Application for a Non-Material Amendment Following a Grant of Planning Permission

Non Material Amendment of previously approved 21/00707/VAR for Variation of condition 1 (Approved plans) of previously approved 20/00771/FUL for Demolition of existing agricultural buildings and development of 6 dwellings Dimmocks Cote 46 Stretham Road Wicken Cambridgeshire CB7 5XL.

To amend the design to the carport of plot 2.

17-491-4-196P - Rev A - Plot 2 - Car Port

DRAWING TITLE
 Plot 2 Car Port

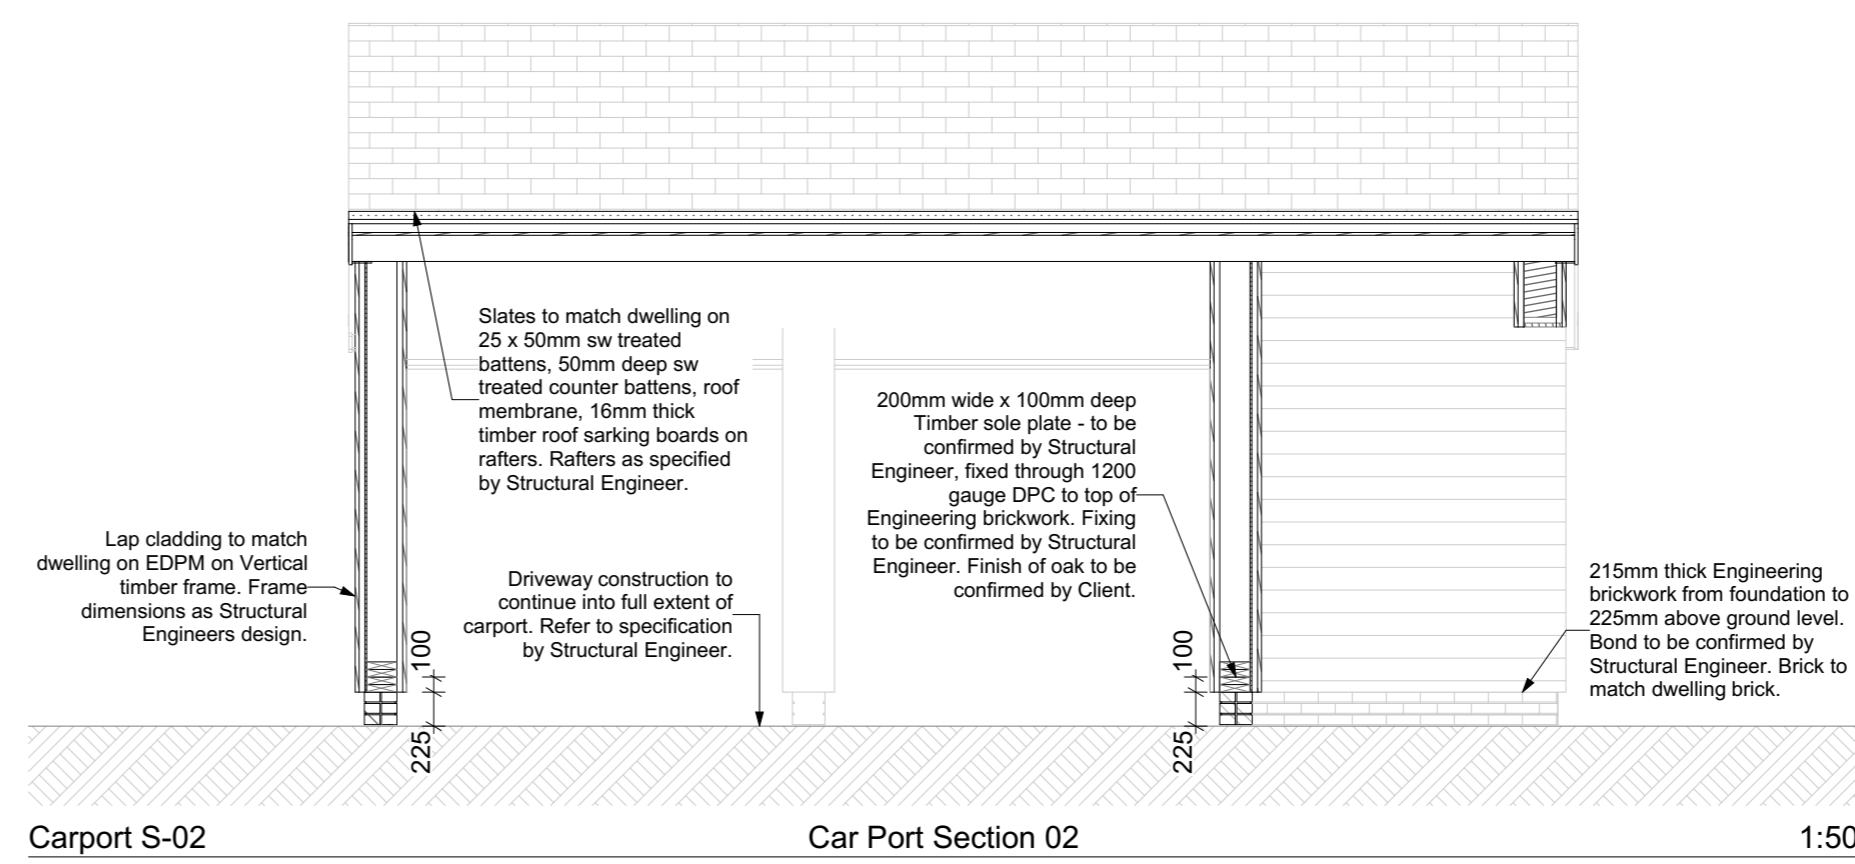
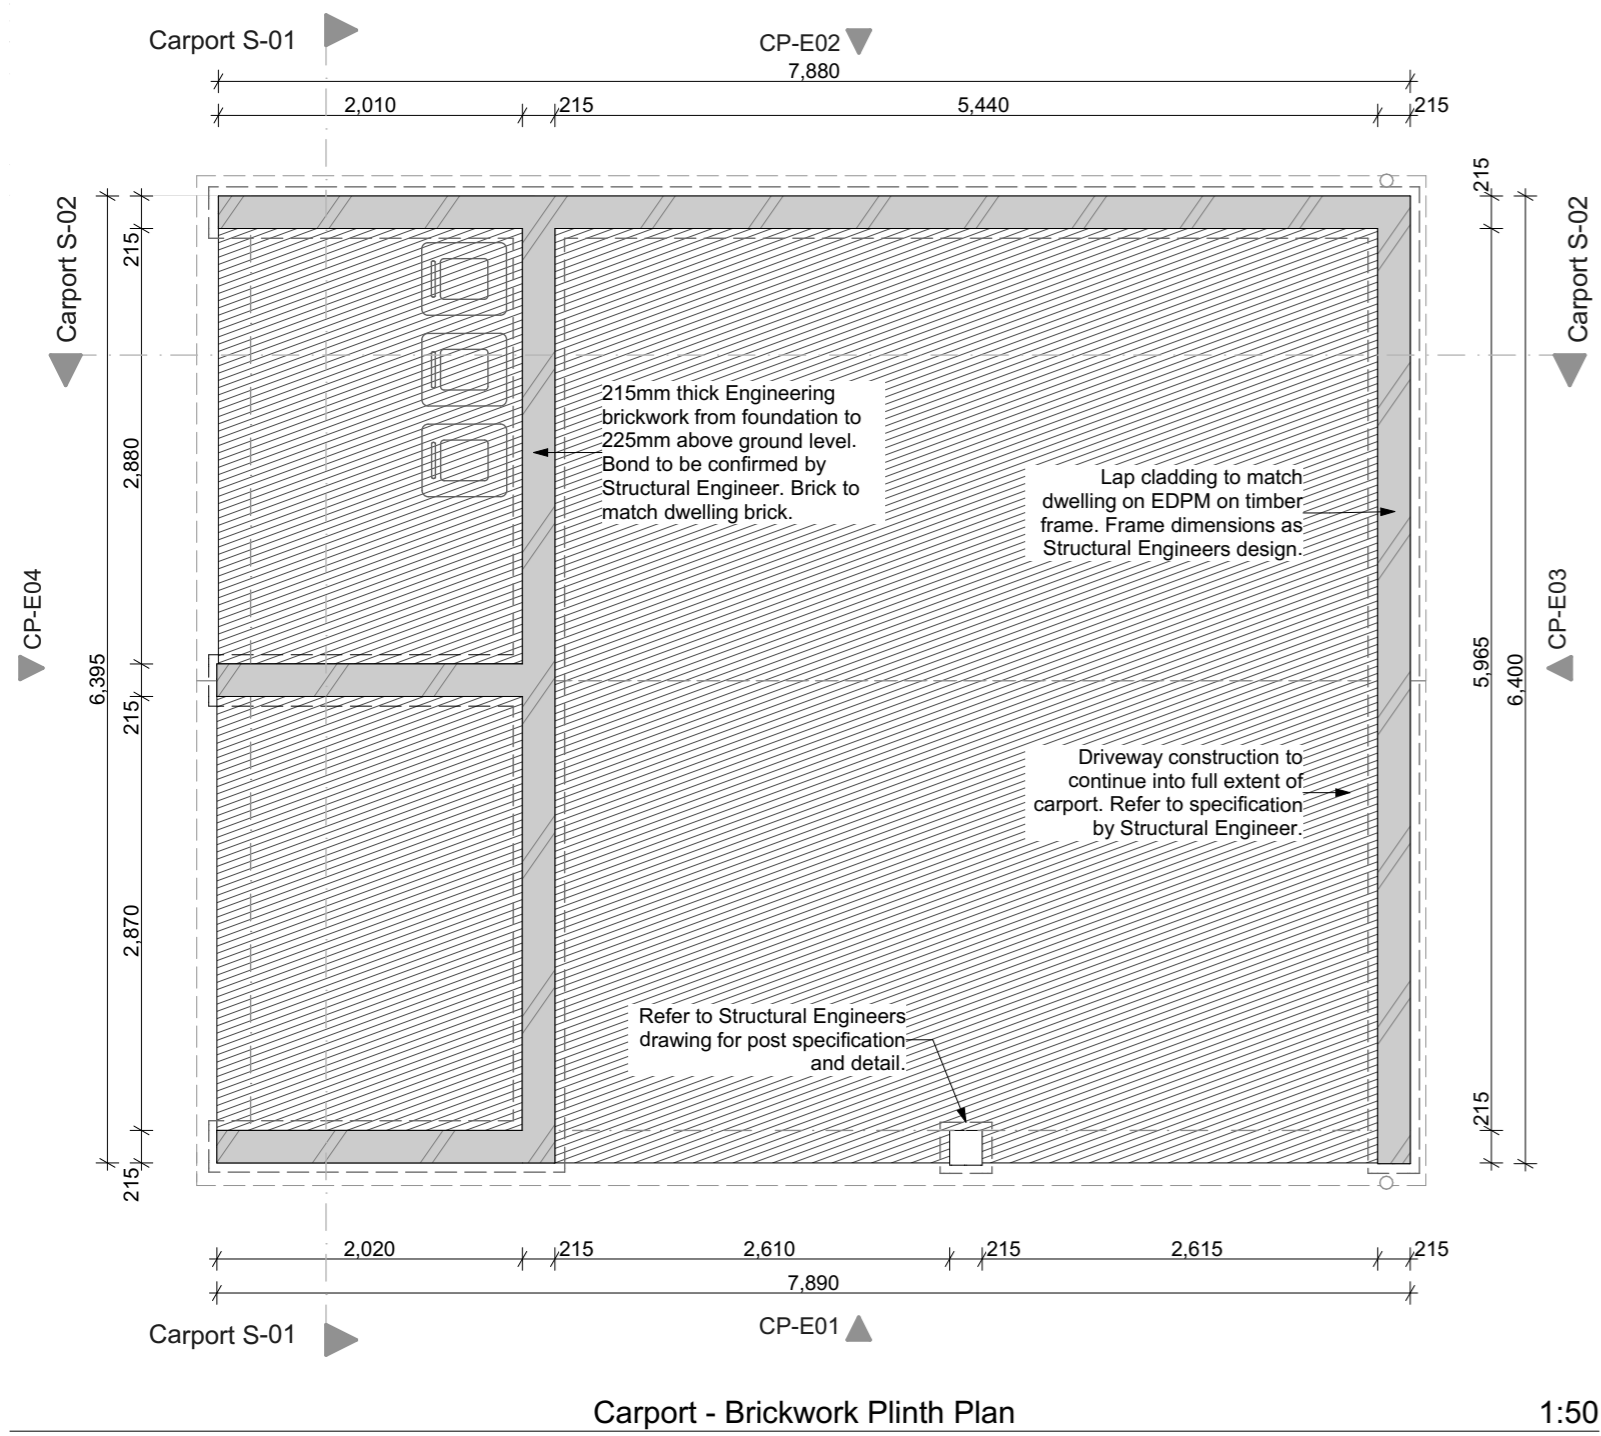
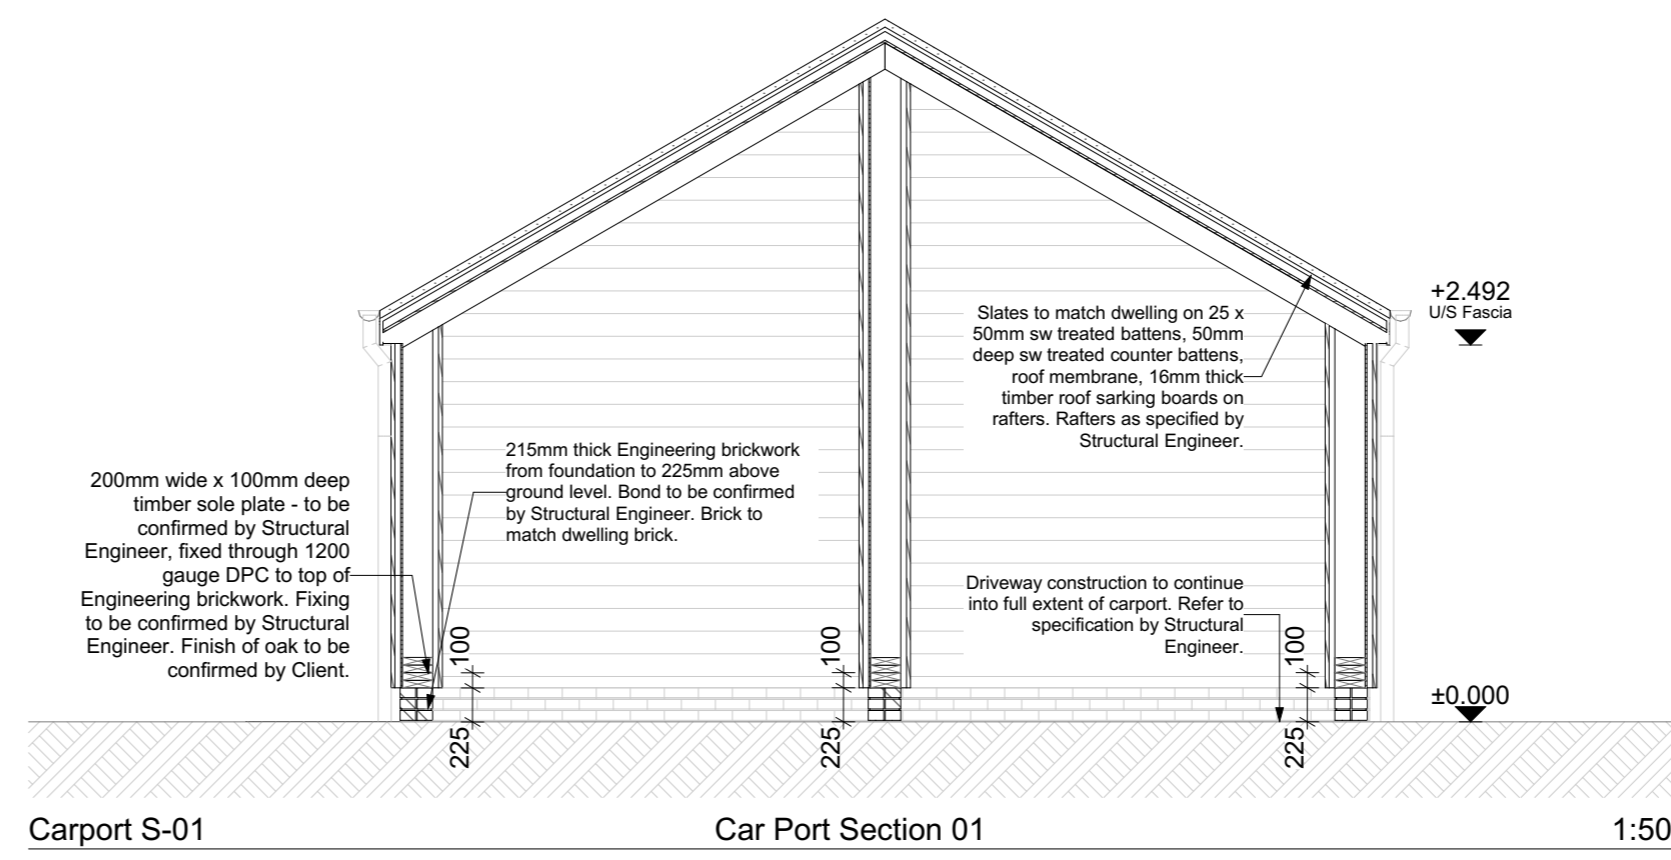
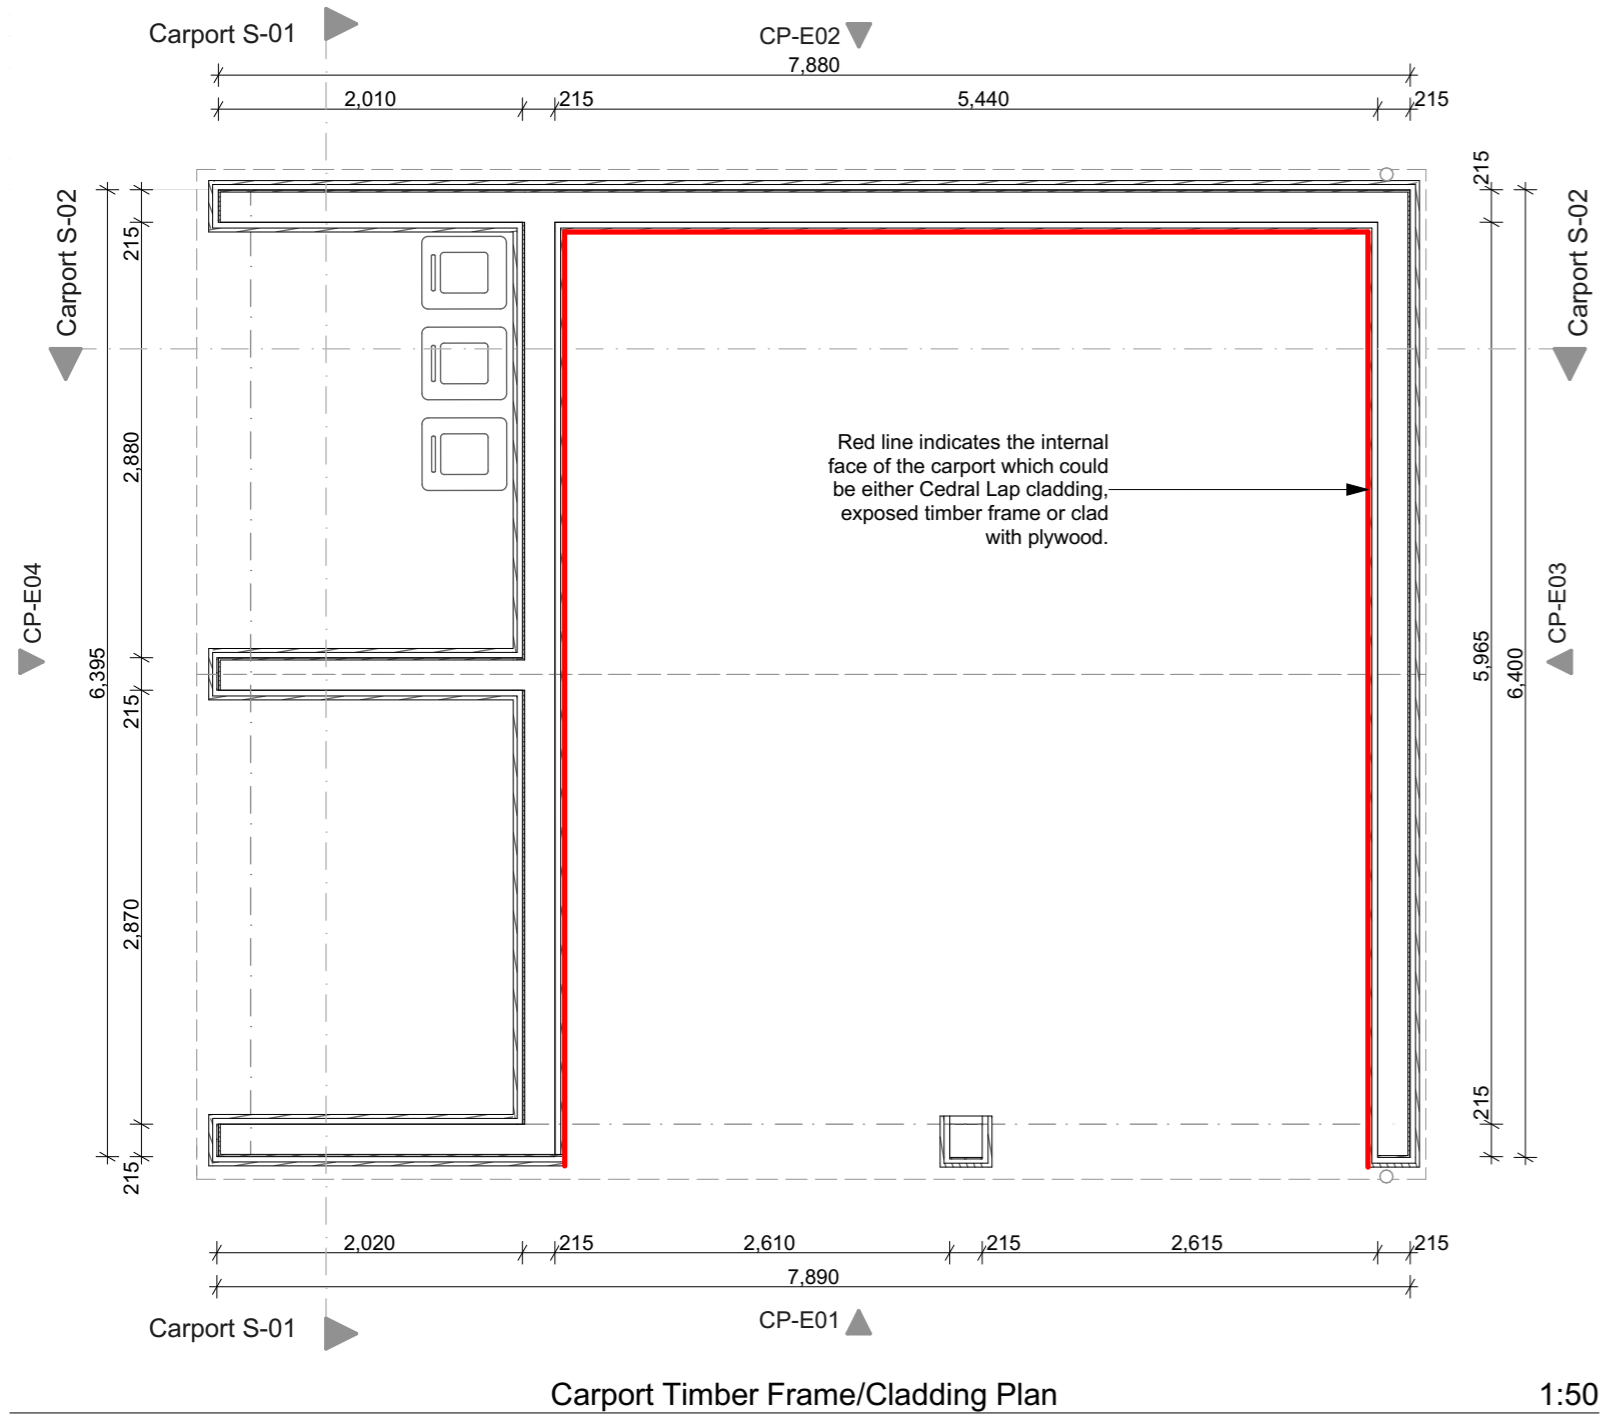
We are seeking to make changes to the Carport of Plot 2 only. We are removing the lean-to roof (where the log and bin store is located) and intend to continue the main pitched roof across here in its place. The sides of the bin and log store are to also be enclosed. Plots 3-6 will remain as original application.
